**WELWYN HATFIELD BOROUGH COUNCIL – DEVELOPMENT MANAGEMENT**  
**DELEGATED REPORT**

**APPLICATION No: S6/2014/1048FP**

**SITE ADDRESS: PET FARM, BELL LANE, BROOKMANS PARK**

**DESCRIPTION OF DEVELOPMENT: FORMATION OF VEHICULAR ACCESS,  
INCLUDING ACCESS GATES AND HARDSTANDING**

DRAWING TITLE:
Proposed Site & Block Plan

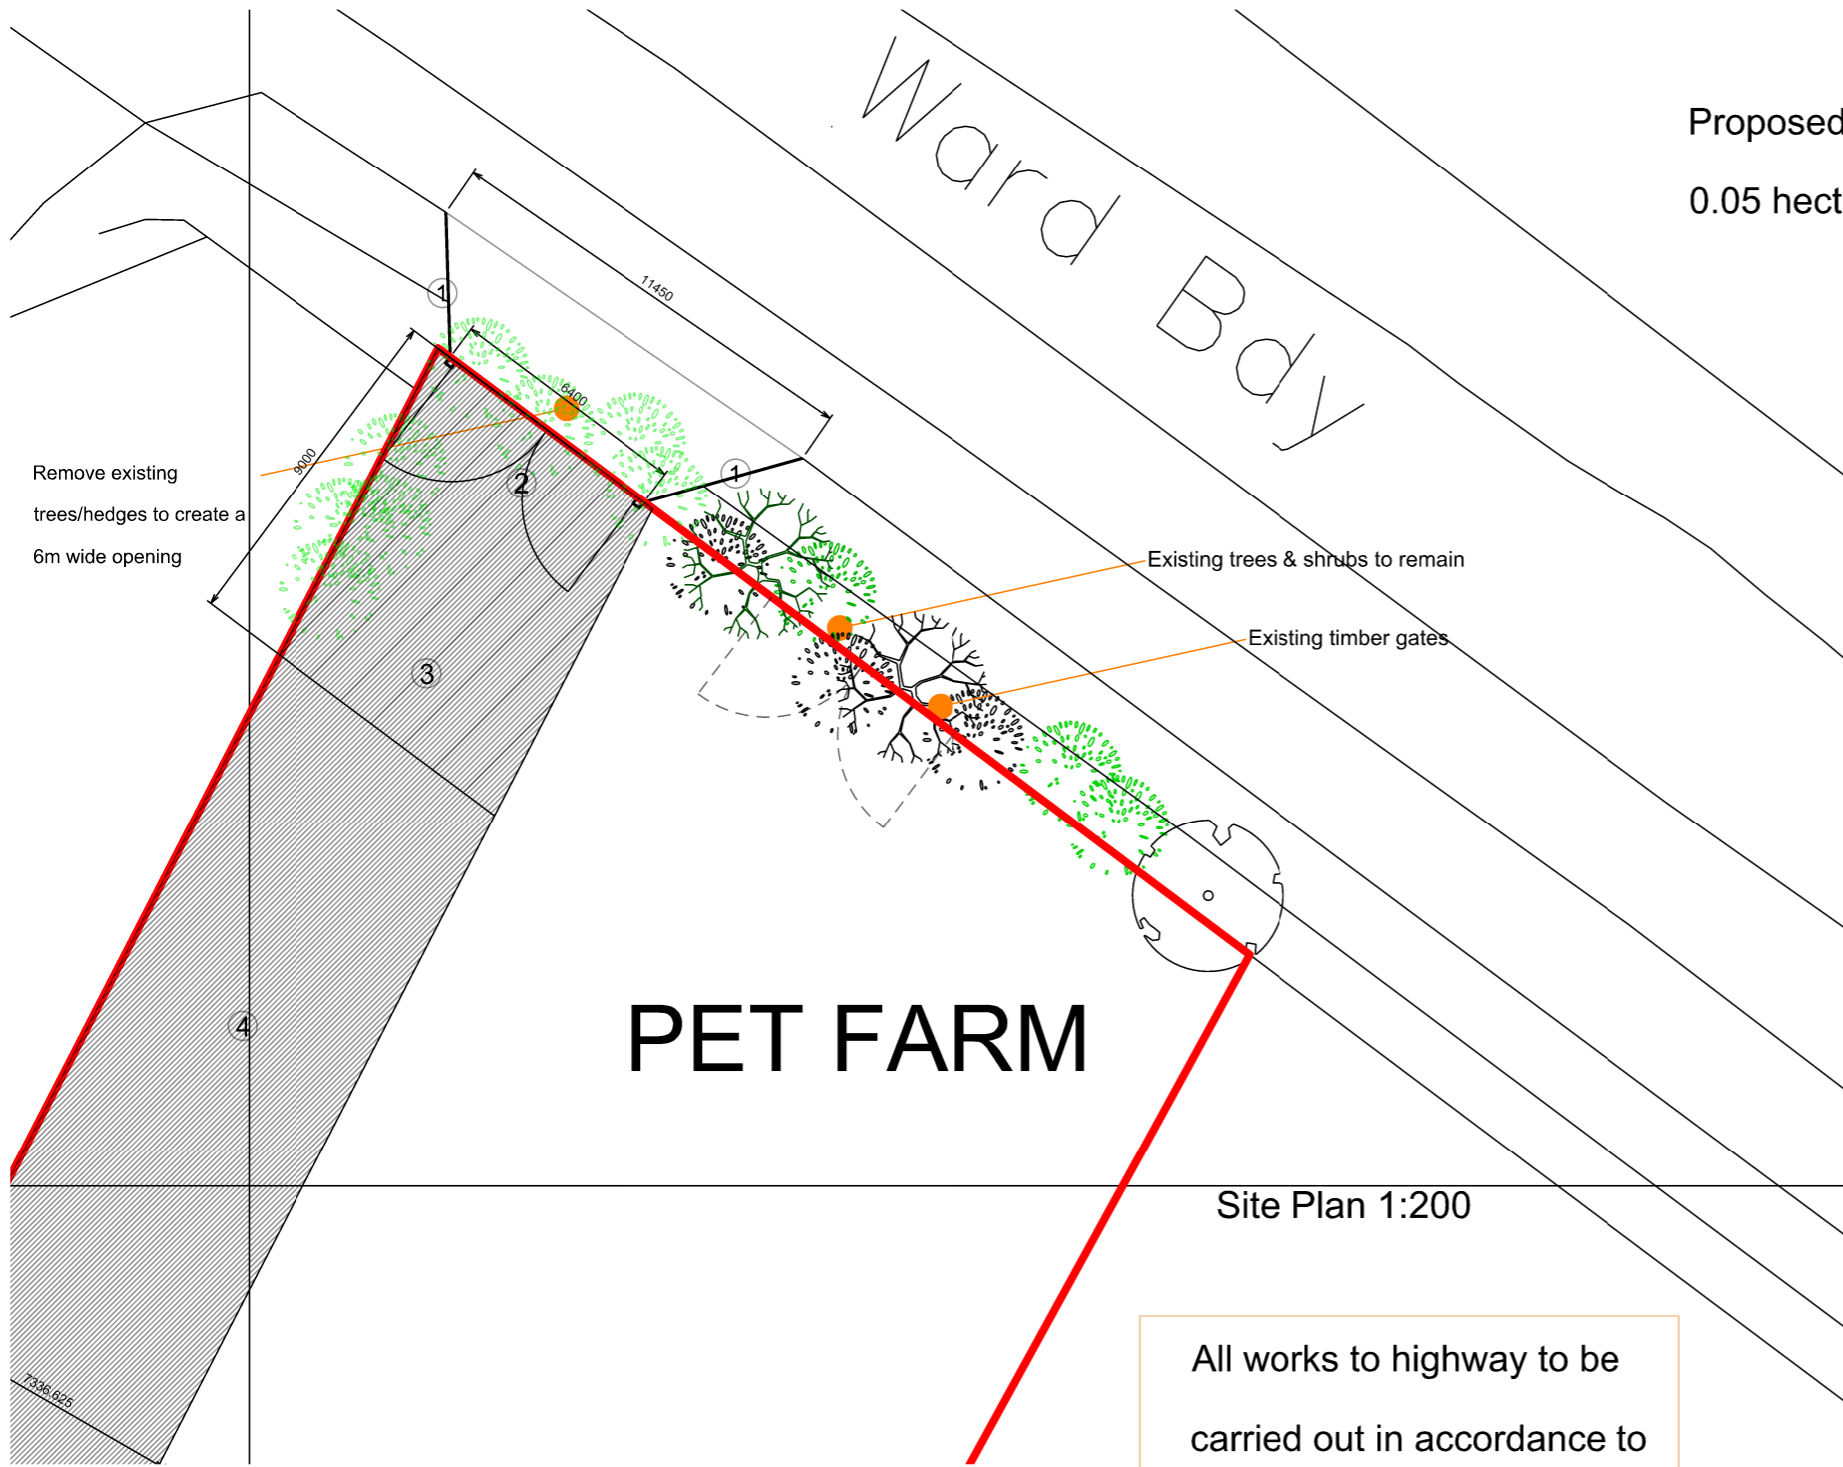
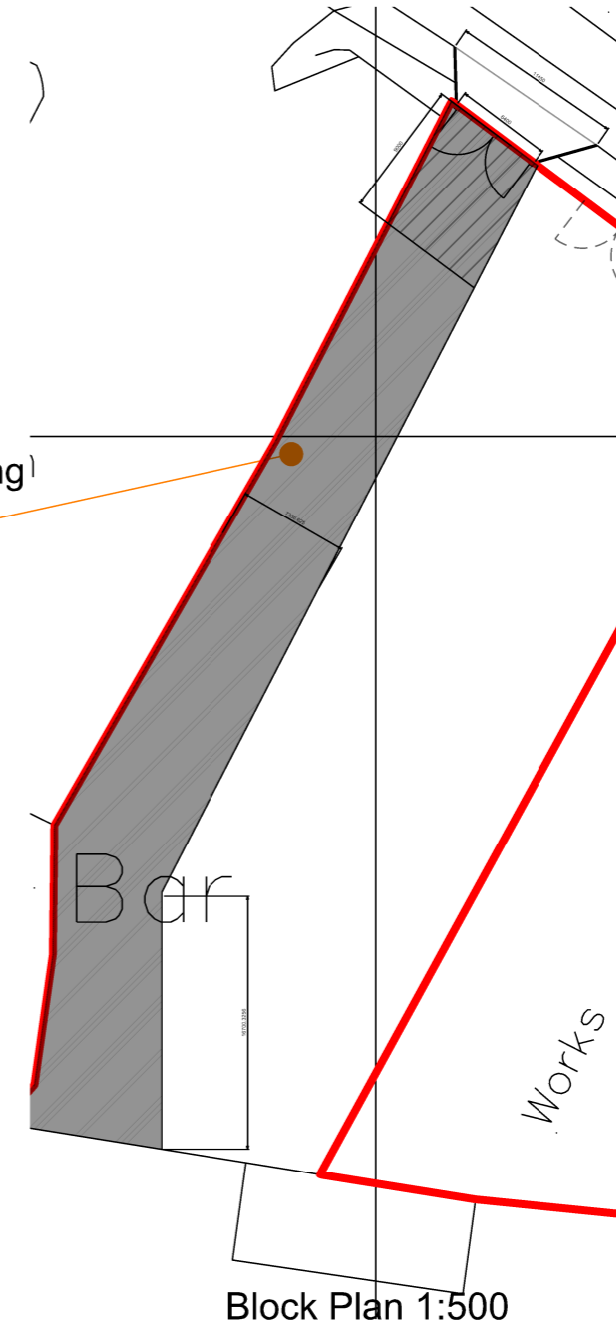
- A hole (gateway) will be punched through the current overgrown hedge/scrub area. Although these are self set trees they do add significantly to the amenity of the area and screen the adjacent eateries
- Hard standings within the RPA (Root Protection Area) of trees should be no-dig or constructed in such a way as to avoid damage.
- No compensatory tree planting has been suggested

- The applicant has failed to identify whether adequate visibility is available from the access.
- Concerned that the applicant may be unable to achieve the necessary visibility splays to the SE (nearside oncoming traffic).

The formation of this new access point, with extensive hardstanding and erection of gates would result in additional built form which inevitably would lead to an increase in the impact on the openness of the Green Belt. By introducing a new driveway of mixed tarmac and block paving would create an extensive area of hard surface that would cross a largely undisturbed field and extend into the site for a considerable distance. This arrangement would erode the openness of the Green Belt.

The scale of the proposed hardstanding and associated access gates required to form the new access would conflict with a purpose of including land within the Green Belt, with in particular the length of the new driveway/hardstanding likely to accentuate the presence of the new feature in the landscape and thus exacerbate its impact. For these reasons, it is considered that the proposal conflicts with the NPPF, which adds to the harm by reason of inappropriateness.

The applicant has failed to identify whether adequate visibility is available from the access and has been unable to achieve the necessary visibility splays to the SE (nearside oncoming traffic). A review of accident statistics for the immediate area identified a number of minor accidents, occurring not only in proximity to highway junctions but also to those limited number of frontage accesses to properties. The formation of a new access shall introduce further points of conflicts, and without adequate visibility shall be prejudicial to highway safety, without the necessary

visibility the access will contribute to the risk of such collisions. Site visit confirms that visibility is significantly constrained and that here is a notable difference in levels behind the highway, and land to be served by the proposed access, this shall further prejudice visibility available to vehicles exiting the site and also represent additional demands upon a driver in terms of leaving the site.

The provision of gated access at the back edge of the carriageway is also unacceptable in this location. Whilst the applicant suggests within the supporting statement that gates will be automatic and operated by remote control, the applicant will not have sufficient control over vehicles seeking to access the site to ensure all vehicles are provided with the means to open the gates (i.e. deliveries and other visitors to the site) and therefore shall give rise to vehicles blocking the A1000 whilst seeking to gain access to the site, prejudicial to the safety of the highway network and contrary to the function of the A1000 in carrying large volumes of traffic and freight.
